Recommendation Report for Works to Tree(s) on trees subject to a Tree Preservation Order (TPO)

REF NO: AW/323/18/T

LOCATION: 2 The Lawn
Aldwick
PO21 4XJ

PROPOSAL: Fell & remove 1No. Hornbeam tree & reduce by 5m over highway & 2m from boundary 1No. Hornbeam tree.

2 THE LAWN

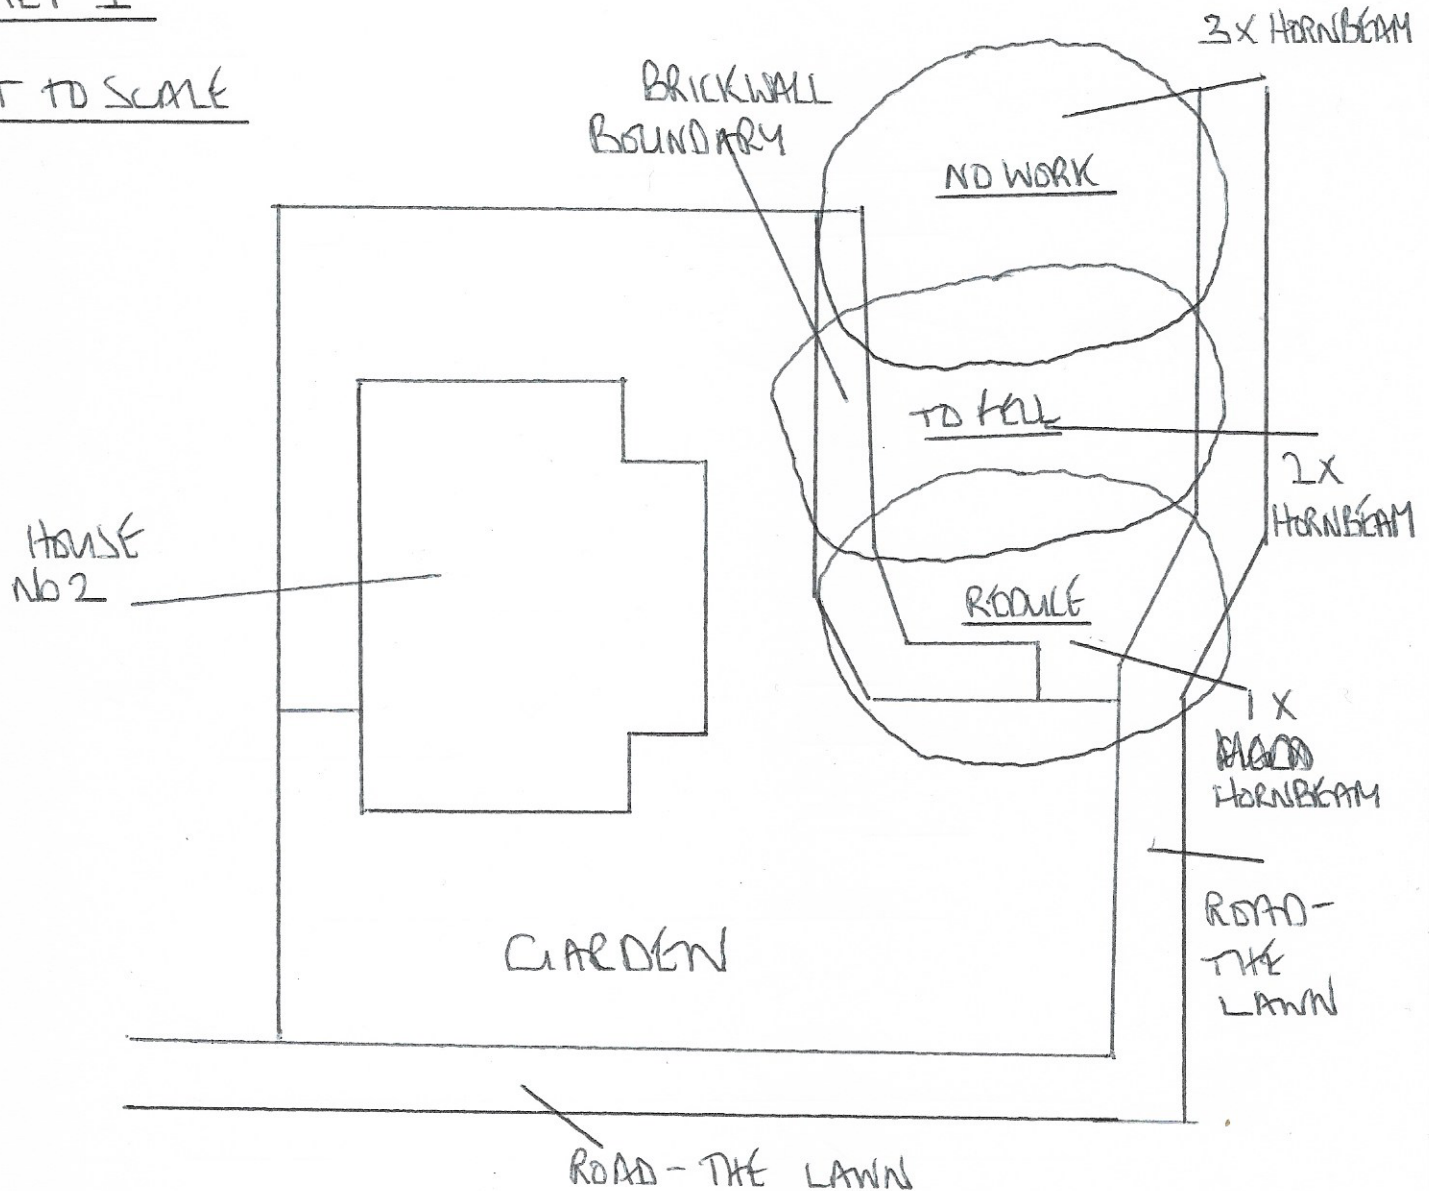
·A pre-application meeting was held between the applicant, adjacent resident and local authority tree officer on 5th November. At this time, a mutually agreeable management plan was discussed and this is reflected in the work proposal being considered here, although it requires clarification, as I describe below:

·It is proposed to undertake the following work to the southernmost tree: 1. Crown lift to achieve

maximum 5metres overhead clearance above the carriageway. 2. Reduce back lateral extent (west aspect only) by maximum 2metres.

·It is proposed to fell the middle tree to ground level. This tree appears to be under considerable physiological distress arising from probable fungal infection low in the main stem/roots, with associated high deadwood content across the upper crown.

·The northernmost tree has not been proposed for any pruning work

·Where whole branches are to be removed and final cuts made close to the trunk or branch union they are to be made as shown in Figure 2 of BS3998:2010

·Where branches are to be shortened back the final cuts are to be made at the correct angle shown in BS3998:2010 and adjacent to a live bud or lateral.
